Internal Ref: EXTERNAL/2024/0020

Inner West Council Response: SSD-76927247 – The Timberyards by RTL Co.

Property: Lots bound by Victoria Road, Sydenham Road, Farr Street and Mitchell Street, Marrickville NSW 2204

### Shadow Diagram

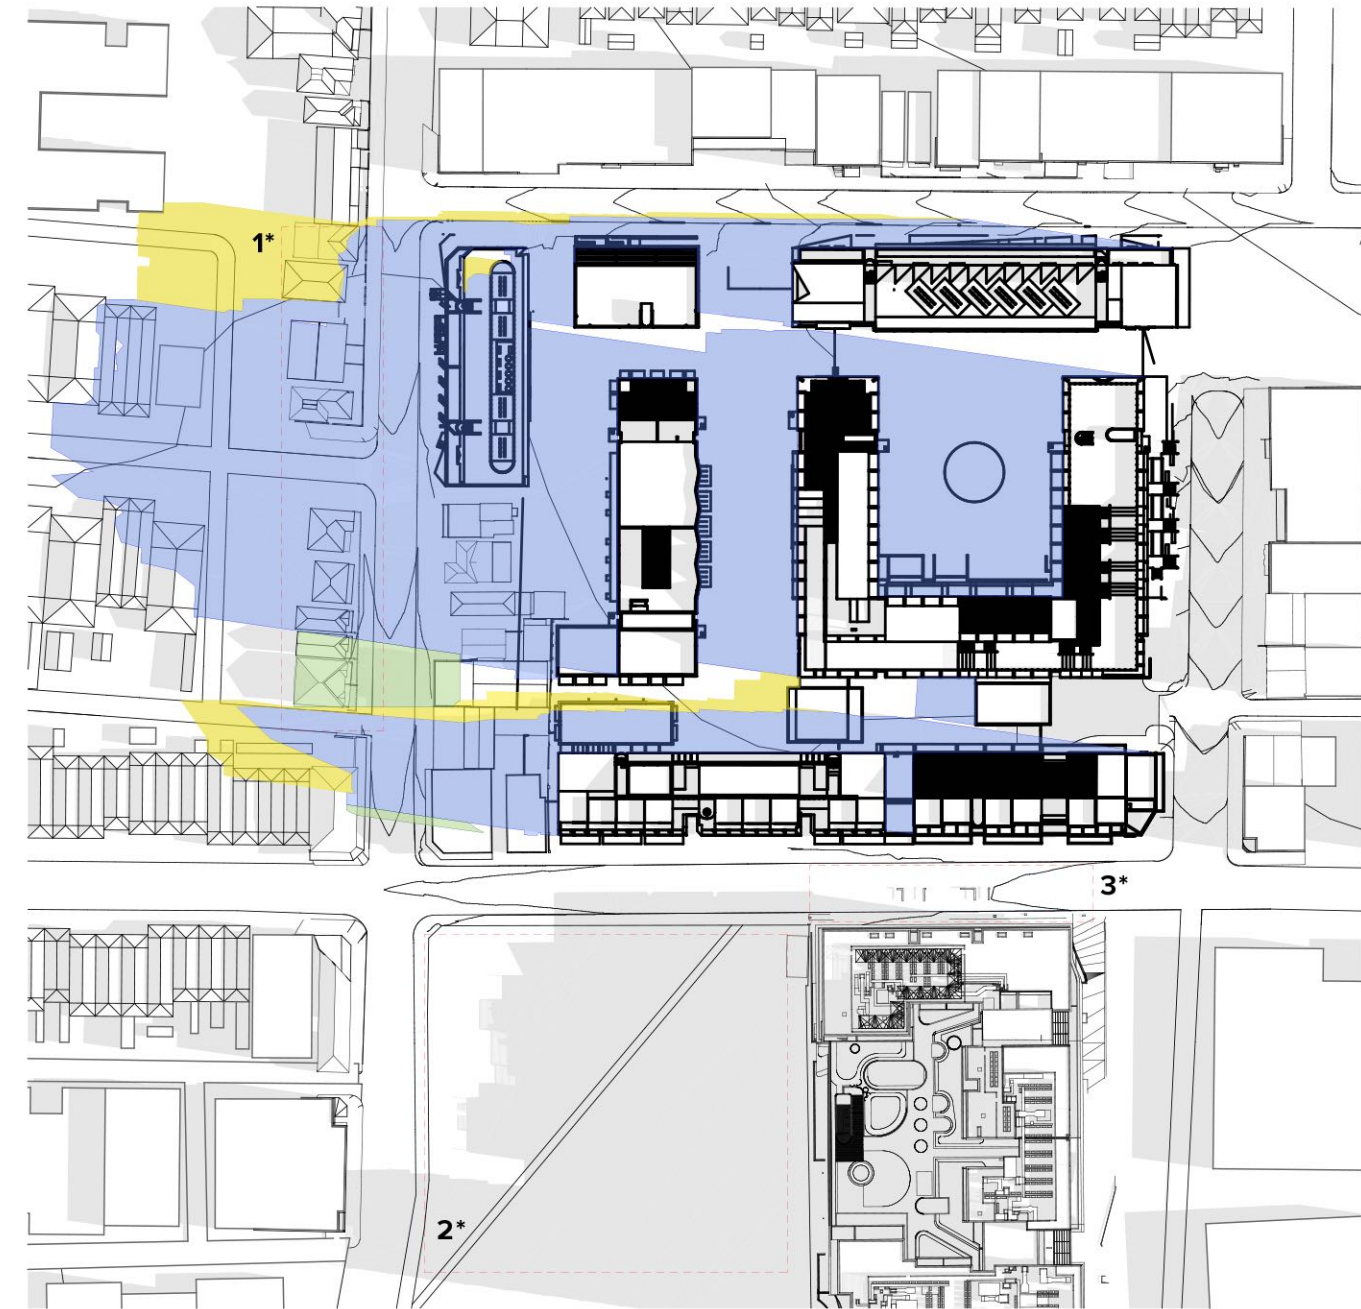
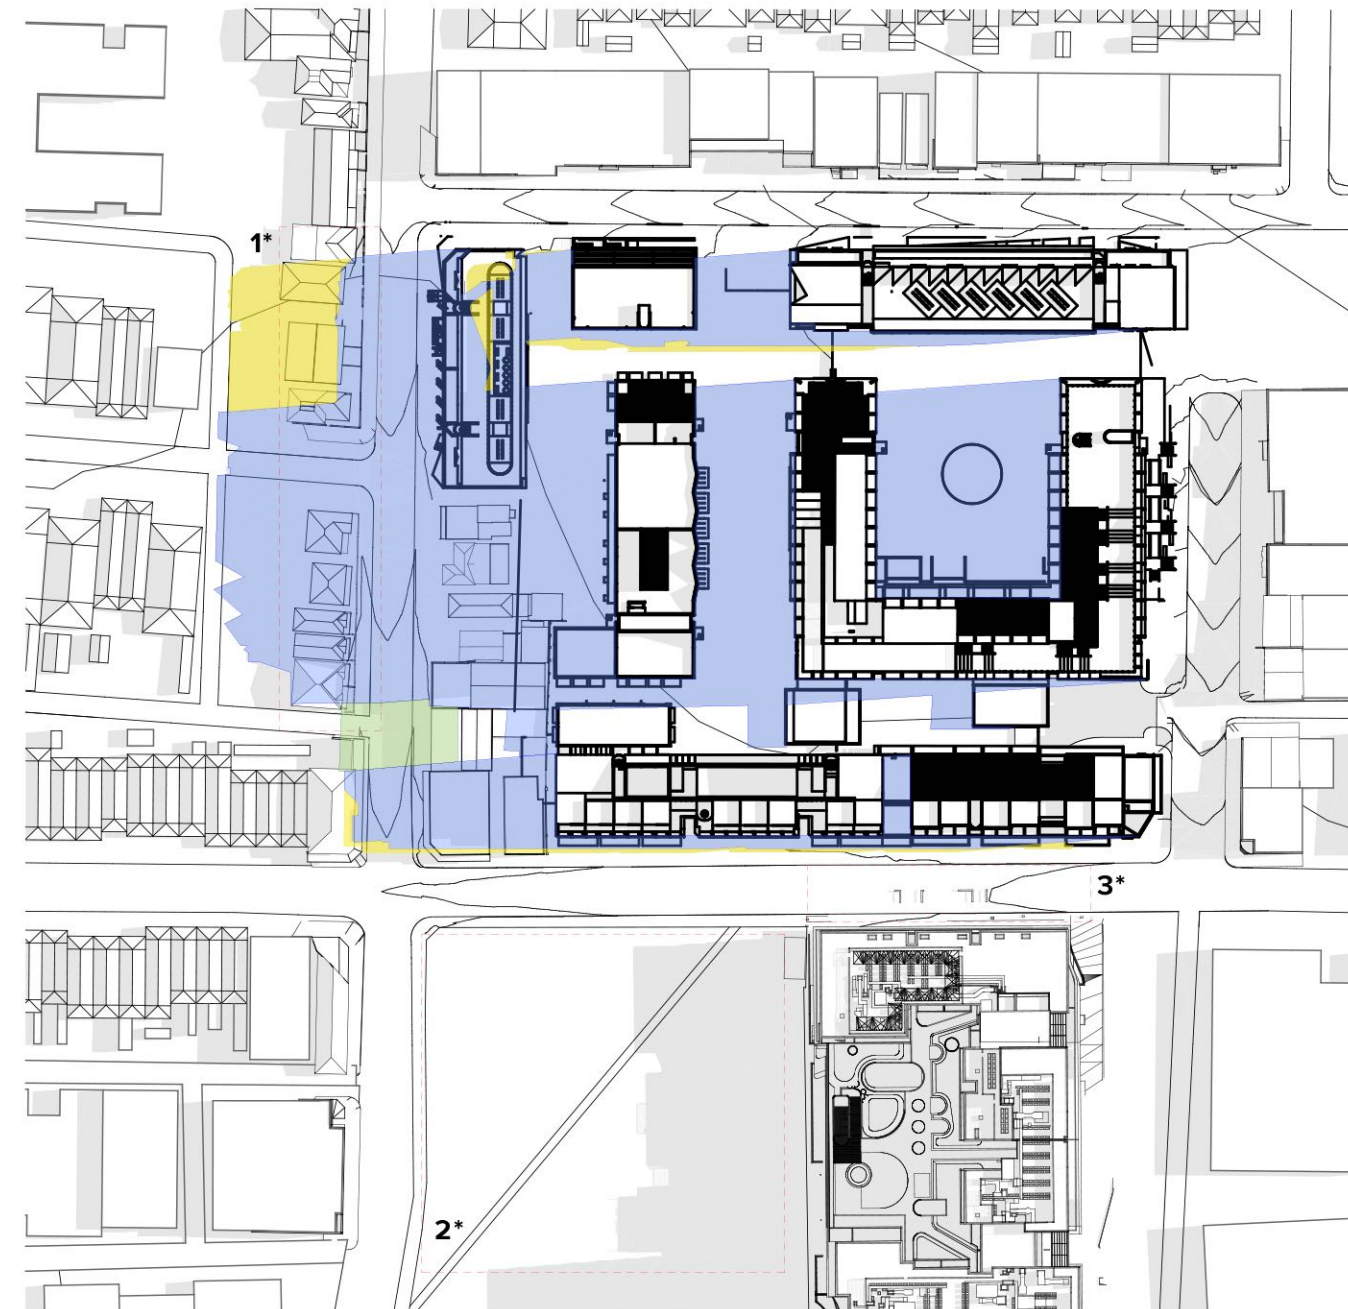
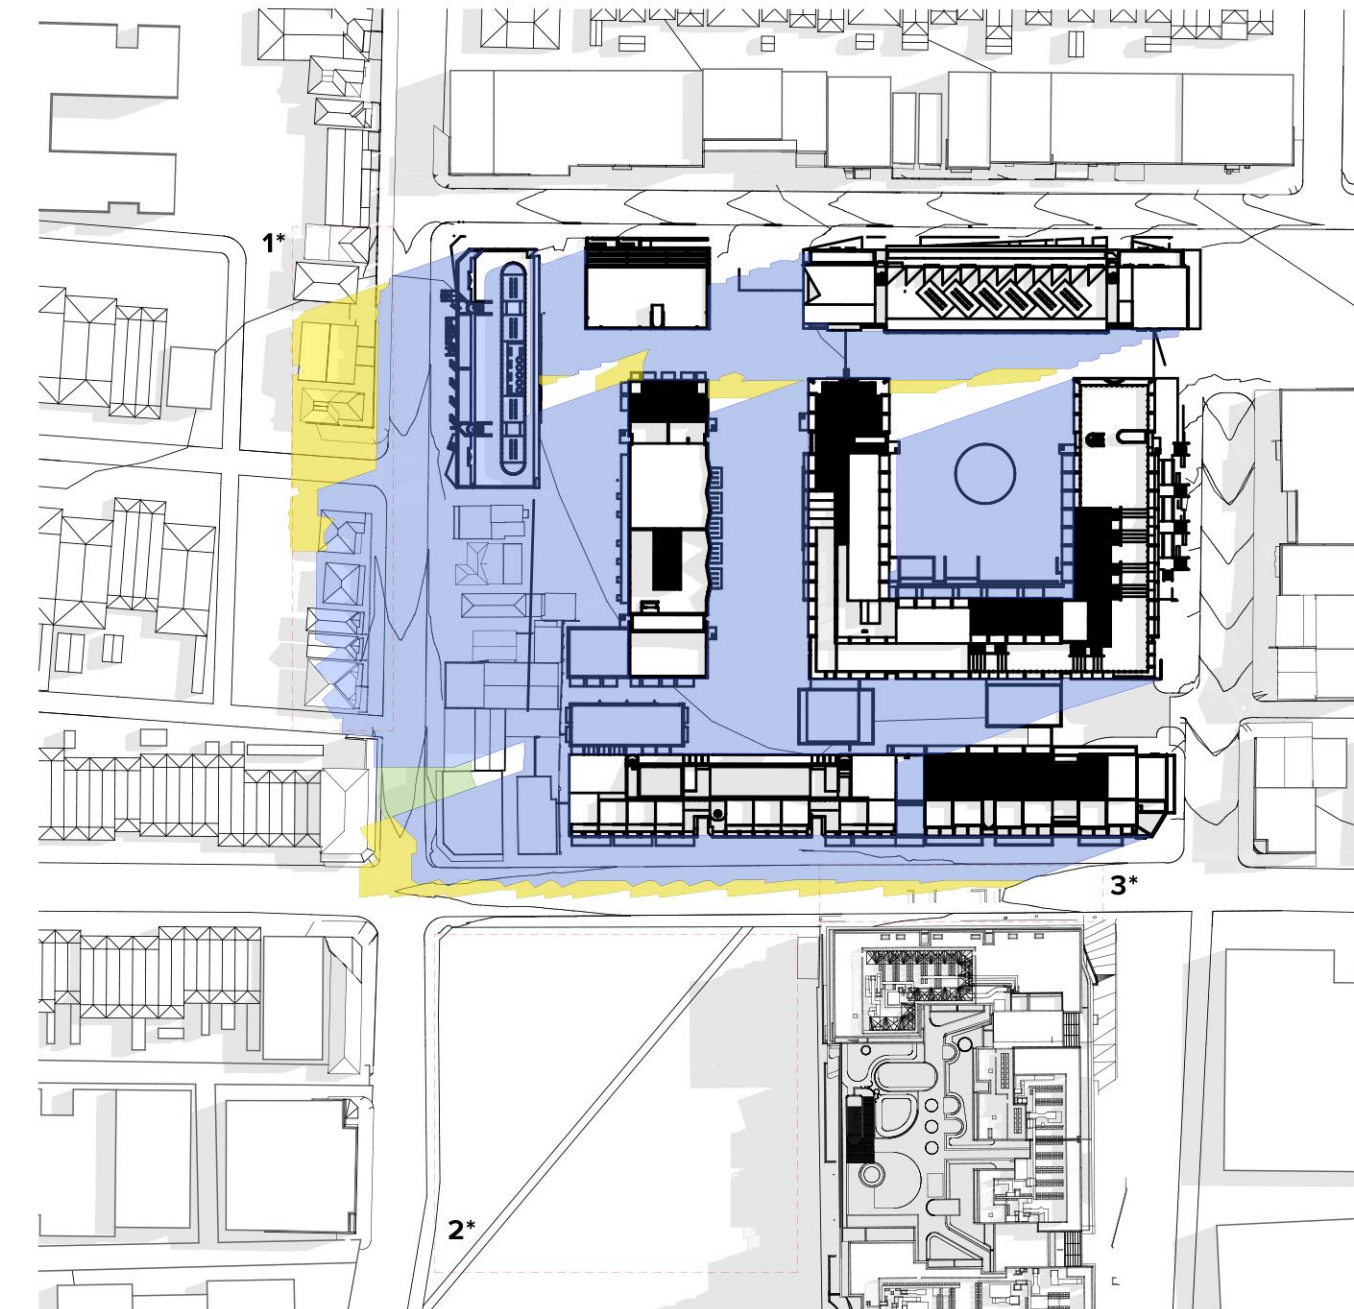
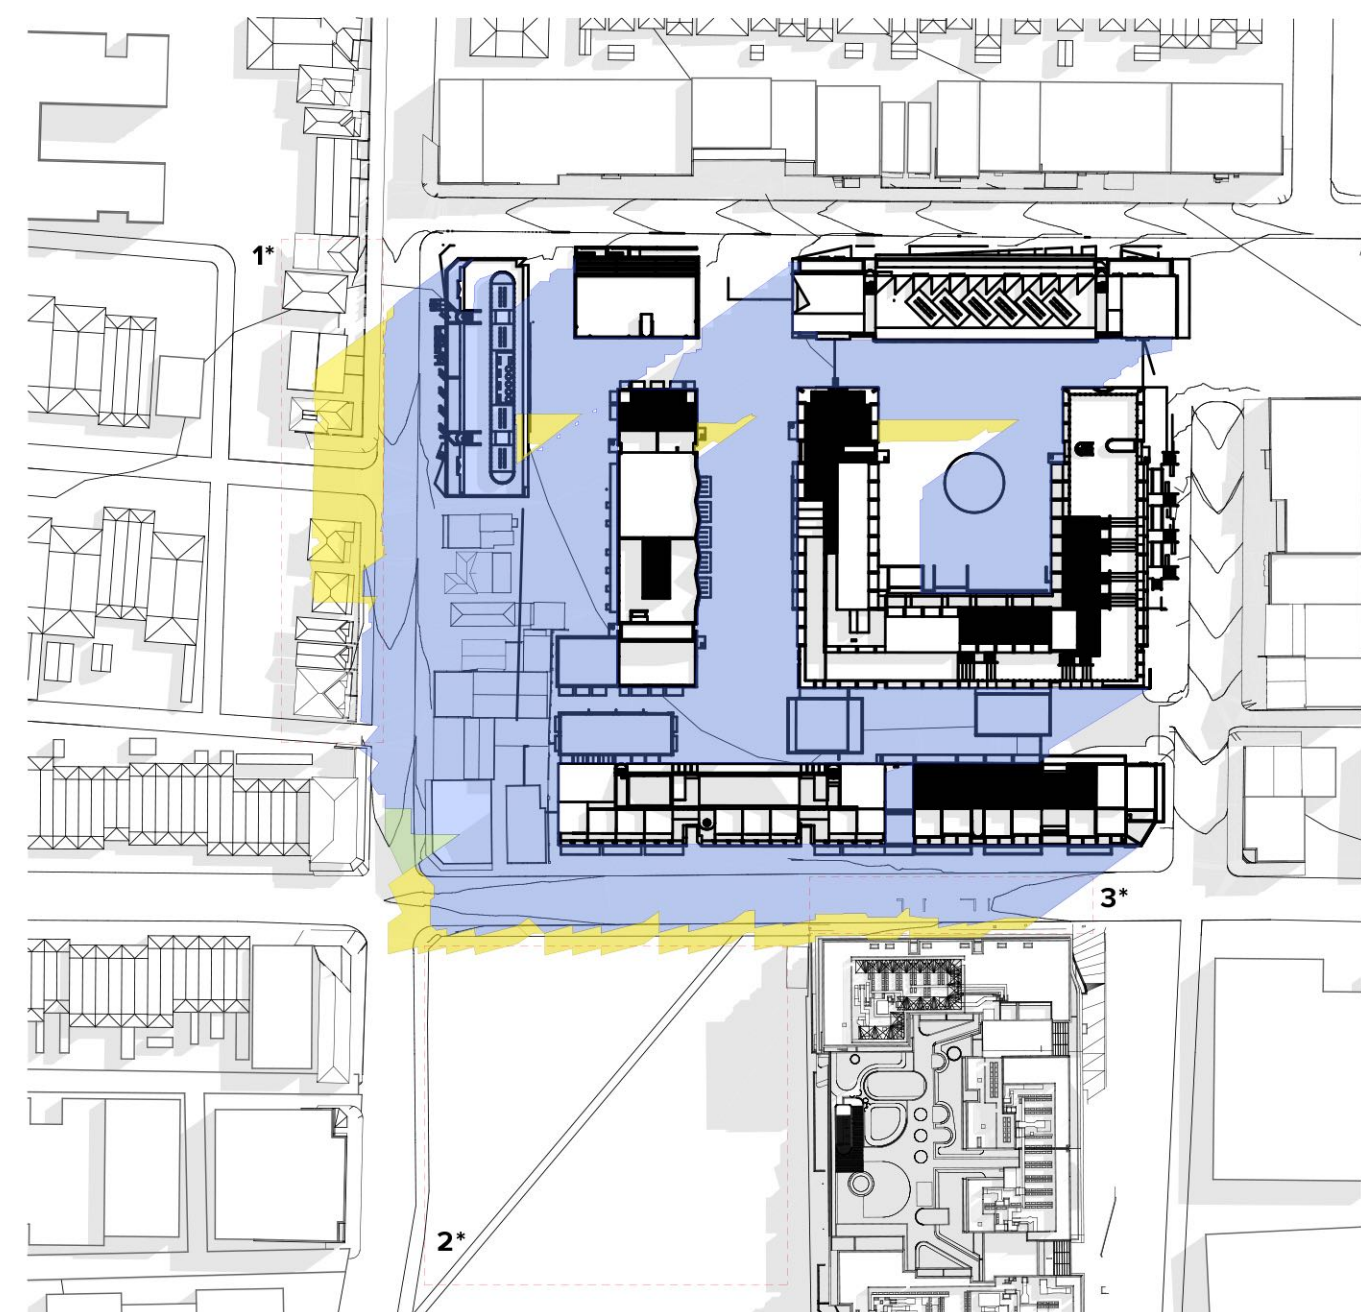
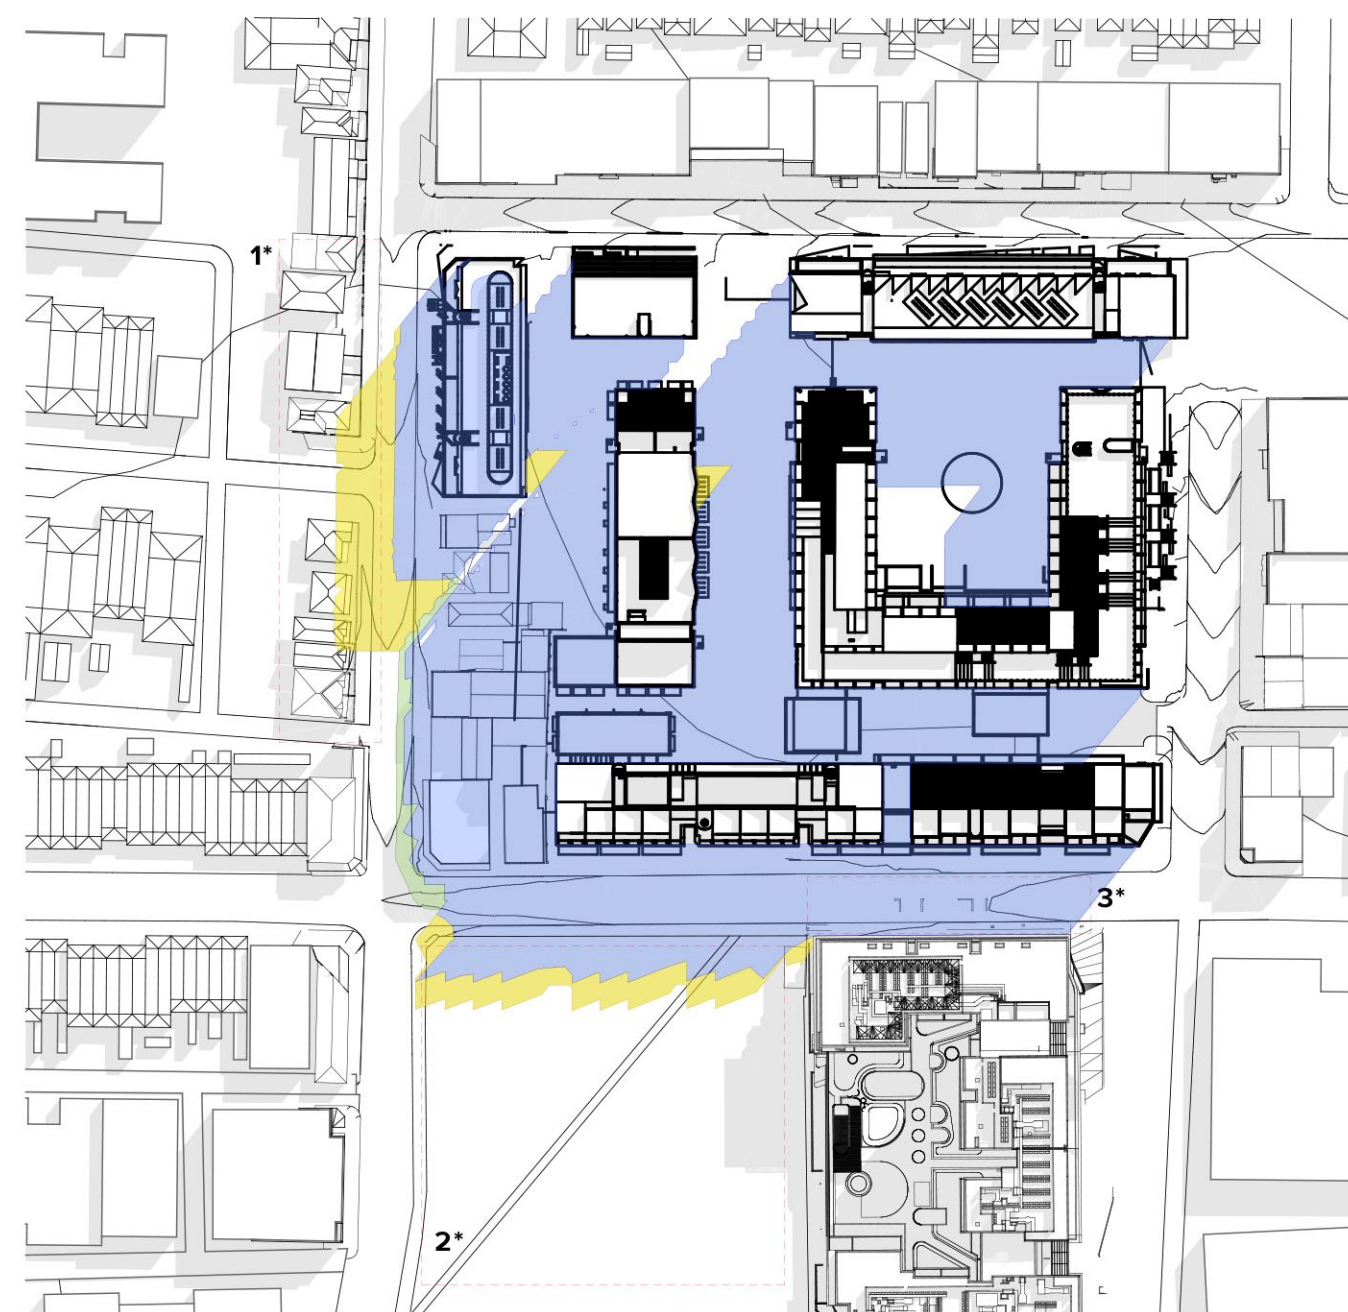
Shadow diagrams in plan view have been submitted, which demonstrate there is significant internal overshadowing within the site.

Based on the limited information provided, the shadow diagrams fail to demonstrate compliant solar access is received to the balconies and associated glazing which service principal living areas along all building elevations.

Furthermore, shadow diagrams in elevation view have not been submitted which demonstrate that the required 2 hours of solar access to the balconies and associated glazing which service principal living areas is achieved for;

- The southern elevation of all buildings;
- The eastern elevations of Buildings A, B, E, F & G; and
- The western elevations of Buildings B, D, E & G.

The current diagrams in plan view demonstrate that the northern elevations of the aforementioned buildings will receive solar access at only 3pm on June 21. The aforementioned eastern elevations receive solar access between 9am-10am, and thus only receive 1 hour of solar access between 9am and 3pm on June 21. The aforementioned western elevations receive solar access from 10am-11am, and thus only receive 1 hour of

solar access between 9am and 3pm on June 21. Given the above, it has not been demonstrated as to how the proposed living rooms and private open spaces of at least 70% of apartments on the site receive a minimum of 2 hours direct sunlight between 9am and 3pm in accordance with the design criteria under Objective 4A-1 of the ADG.
